Rezoning Transportation Analysis

Petition Number: 2023-134

| Date | Description |
|----------|-------------------|
| 11-21-23 | First Review (NK) |

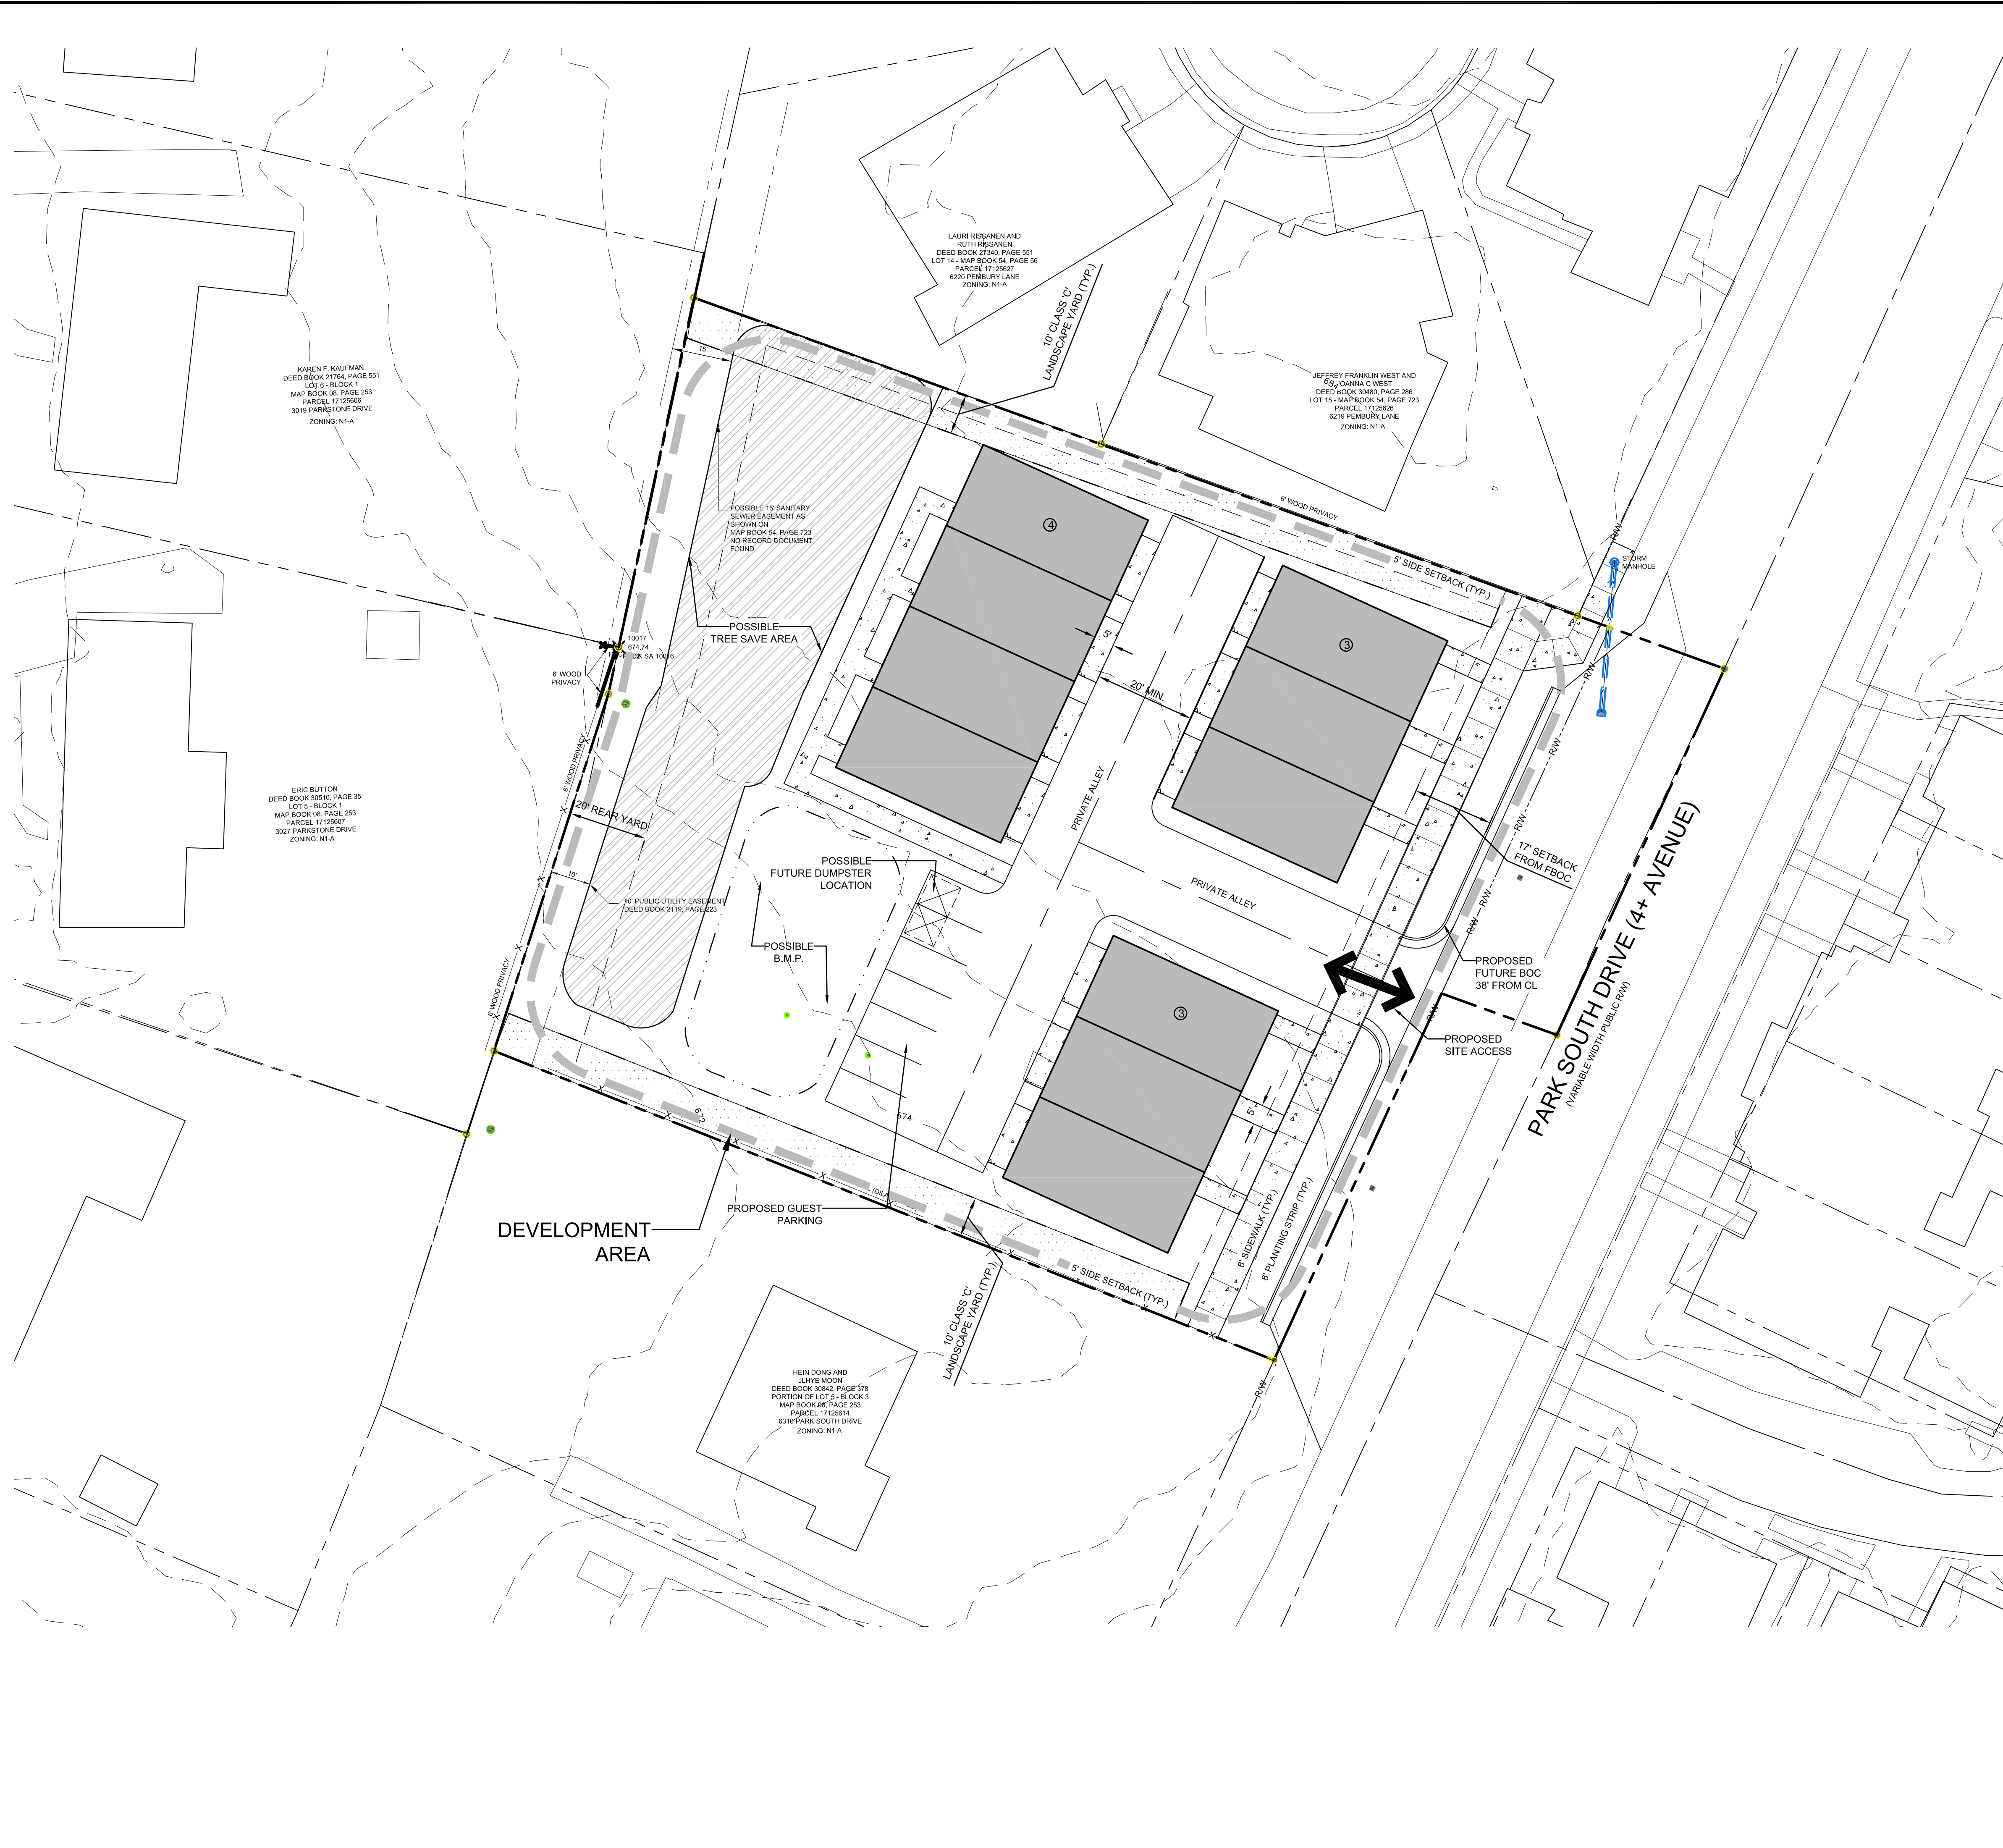
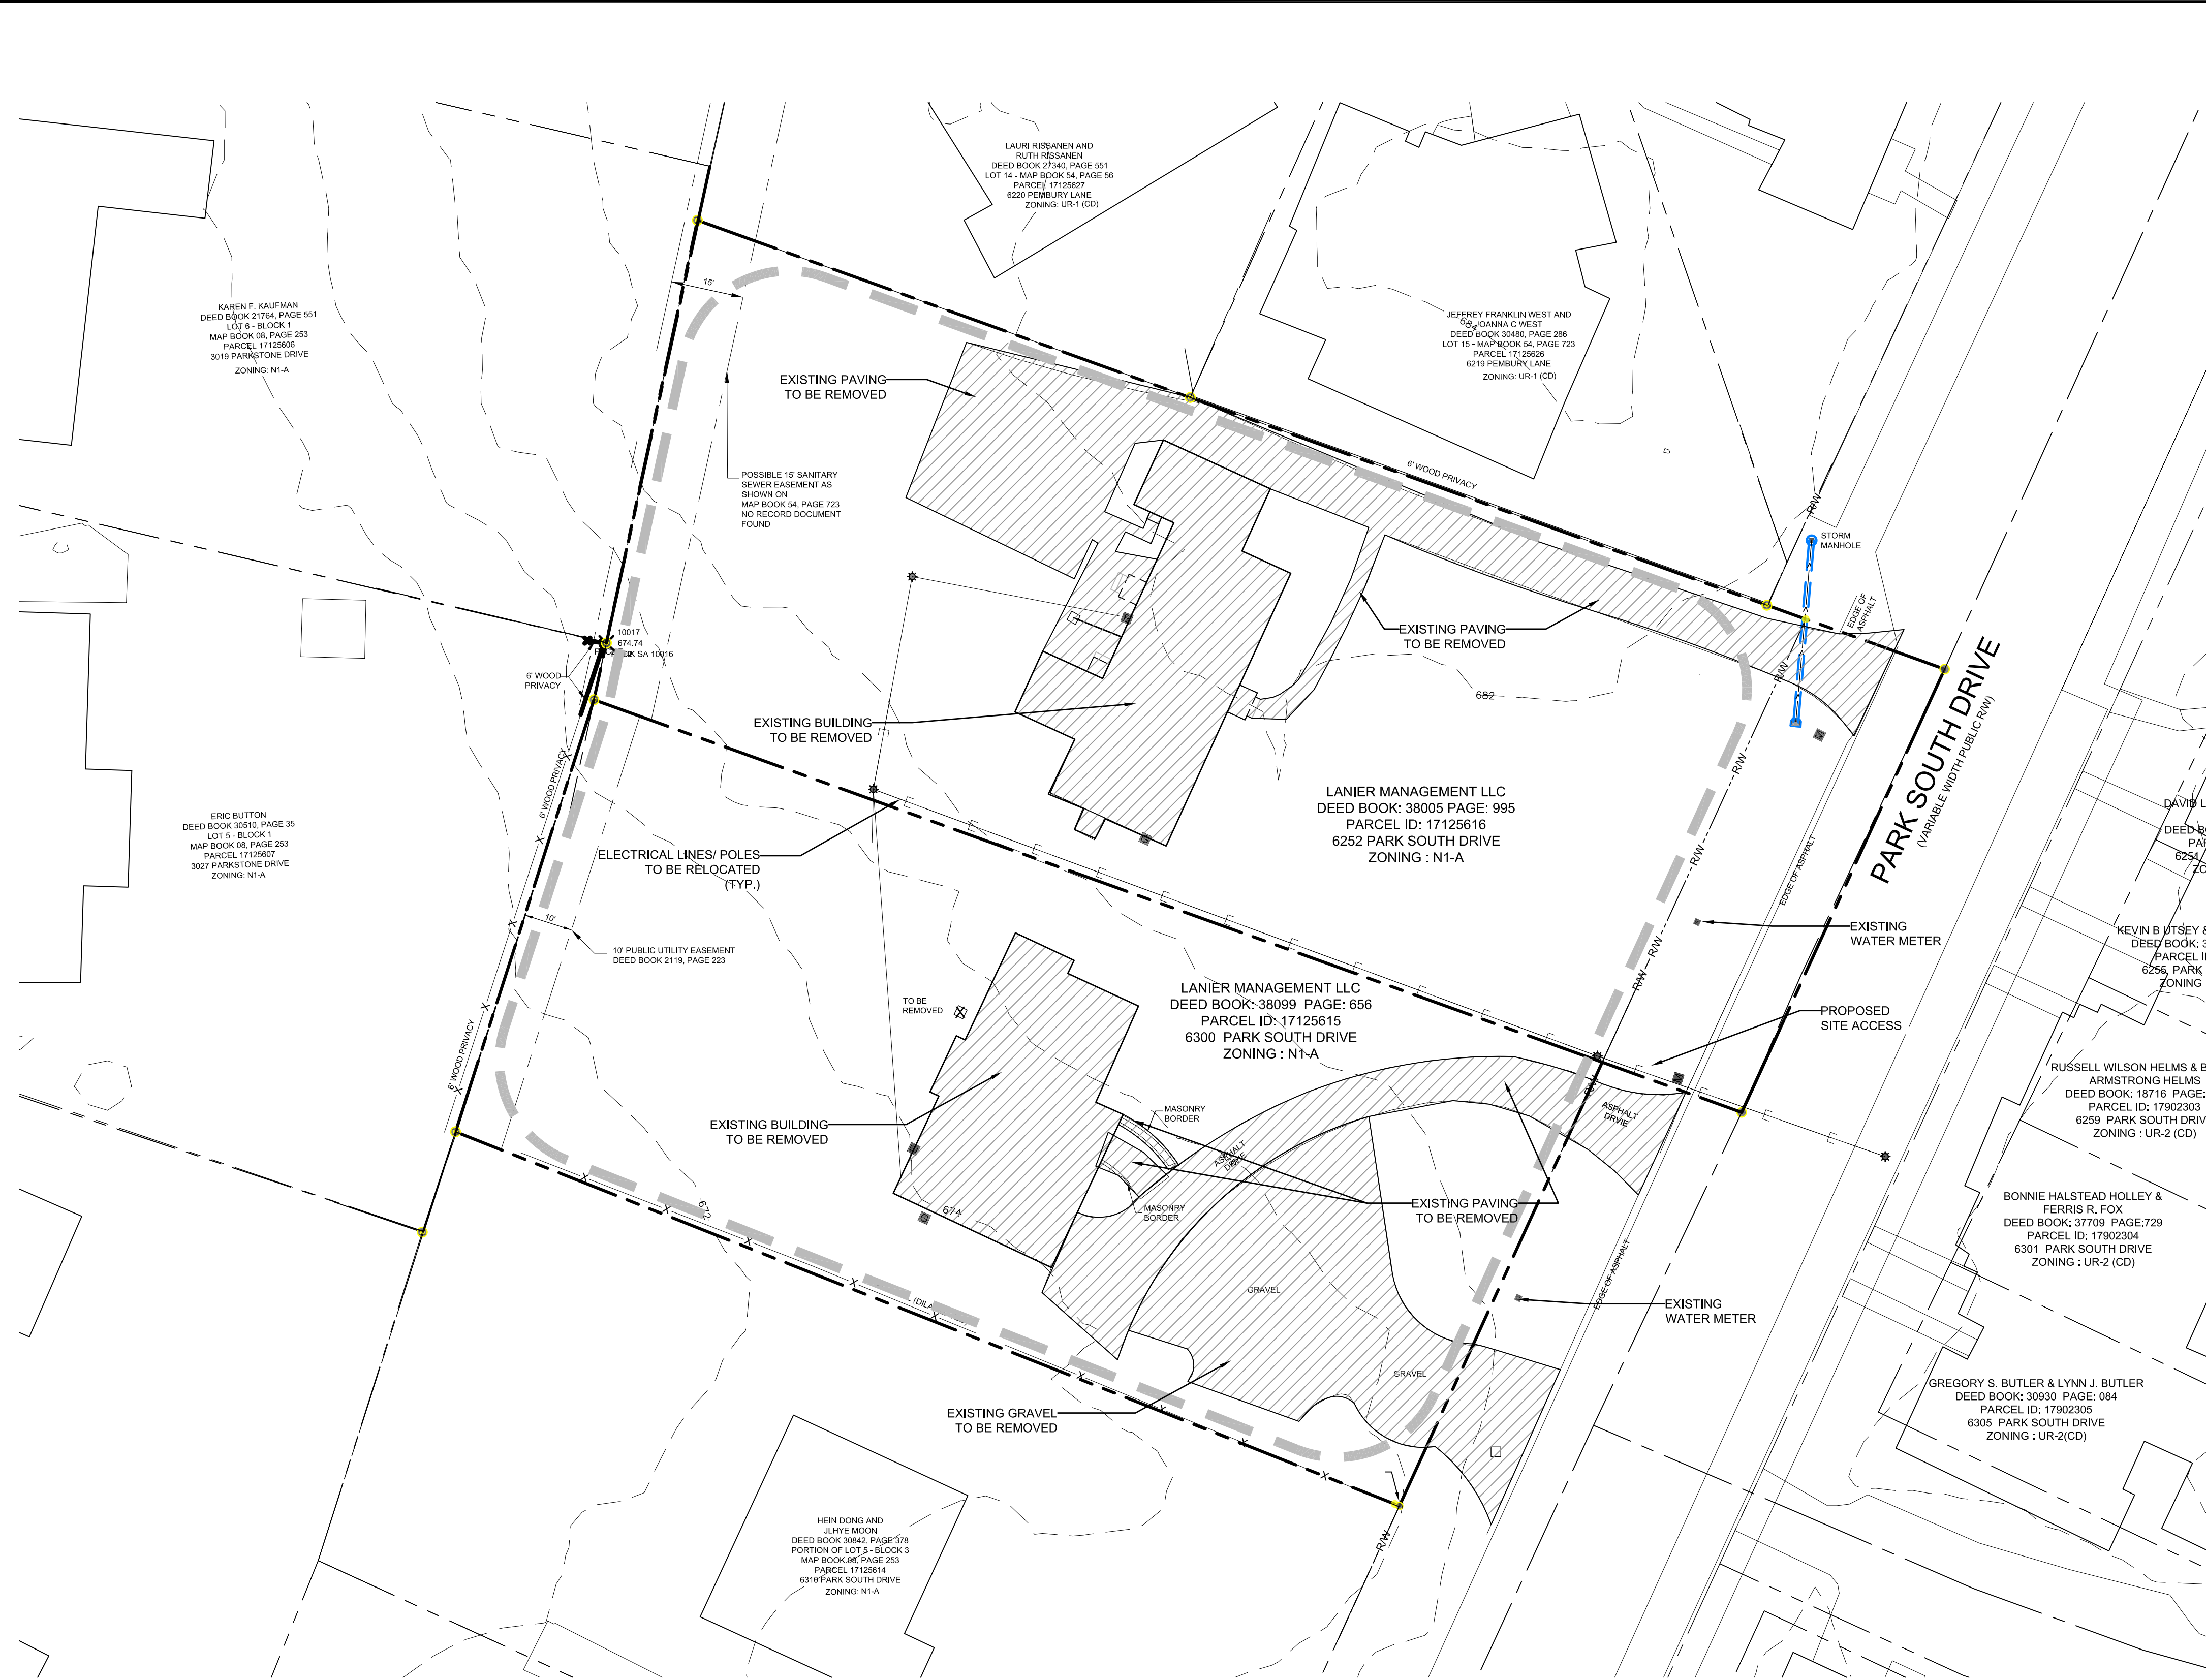
~~**Park South Drive:** Location of future curb and gutter to be moved 38' from centerline to back of curb.~~

~~Label and dimension the curb and gutter from the centerline for each road on the site plan.~~

3. Revise site plan and conditional note(s) to commit to dedicate 56' right-of-way from the road centerline. The site plan shall label and dimension the right-of-way from the road centerline.
4. Revise site plan and conditional note(s) to commit to construct bicycle facilities by locating the curb and gutter 38' from the center line.
5. Revise site plan and conditional note(s) to commit to aligning driveway with the driveway located on the opposite property

6. Revise site to commit to a cross access stub connection to the southern abutting property per Article 31 of UDO. Add a conditional note committing to recording a cross-access easement to both the northern and southern properties.
